An
Coimisiún
Pleanála

Commission Order
ABP-321056-24

Planning Register Reference Number: ED24/110

WHEREAS a question has arisen as to whether a change of use from ground floor public house with overhead residential to three bed residential unit at Georges Street, Gort, County Galway, and associated internal works is or is not development or is or is not exempted development:

CLIENT: CARLINE QUINN
 PROJECT: PROPOSED CHANGE OF USE @ STATION ROAD, GORT
 DRAWING TITLE: PLANS & ELEVATIONS OF PROPOSED DWELLING HOUSE

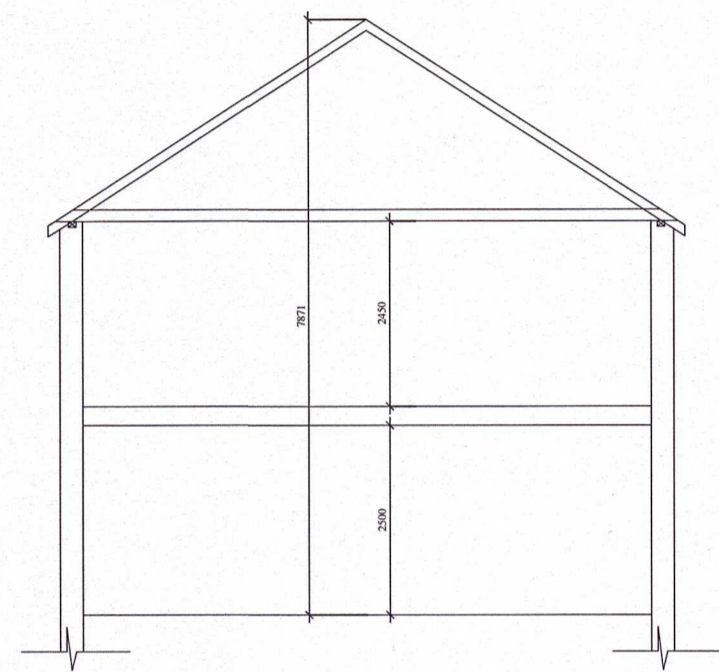
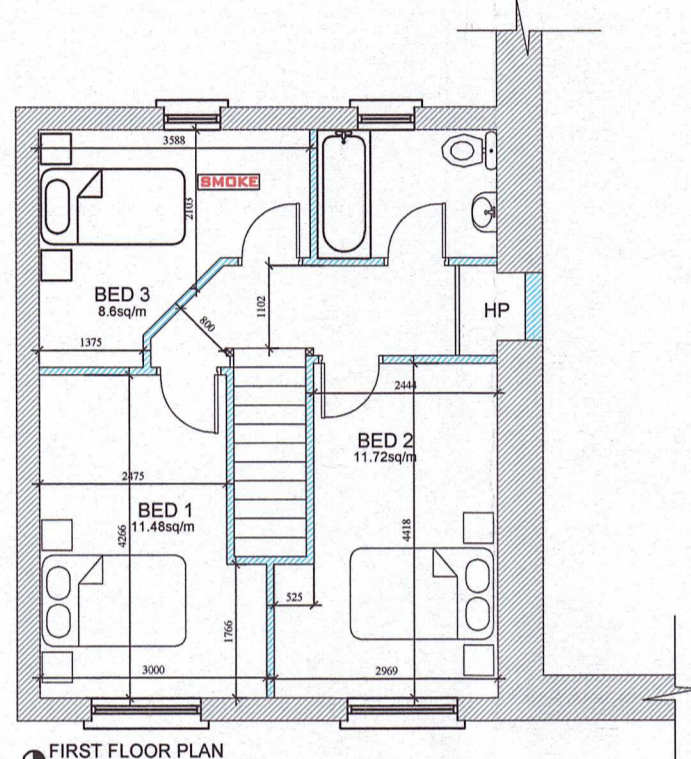
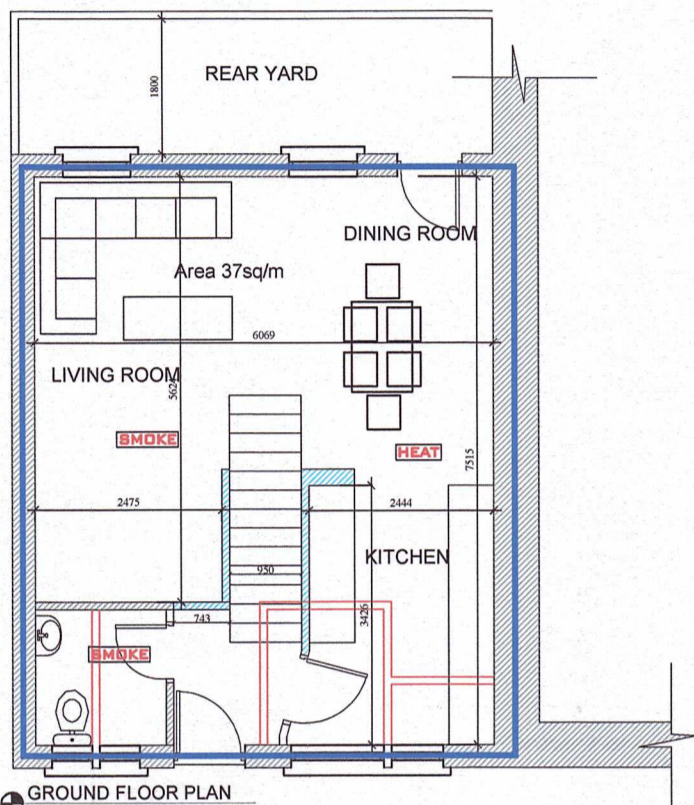
- (c) the first-floor residential use forms part of an established unit on Georges Street, and the subdivision of that residential unit to provide a second residential unit, with the ground floor public house, is a material change of use;
- (d) the subdivision of a residential unit to provide two residential units is not exempted development having regard to Section 3(3) of the Planning and Development Act, 2000 (as amended);
- (e) the first-floor residential use forms part of an established unit on Georges Street which is a Protected Structure and in the absence of evidence of a s.57 declaration would not come within the scope of exempted development under Article 10(6)(d)(viii); and
- (f) The proposed development would not come within the scope of exempted development under Article 10(6)(c).

In any event, the restrictions on exemptions provided for in Articles 10(d)(vi) and 10(6)(d)(xi) of the Planning and Development Regulations 2001, (as amended) applies, as the proposed residential unit would not provide storage spaces in compliance with the minimum storage requirements of the “Sustainable Urban Housing: Design Standards for New Apartments – Guidelines for Planning Authorities” issued under section 28 of the Act.
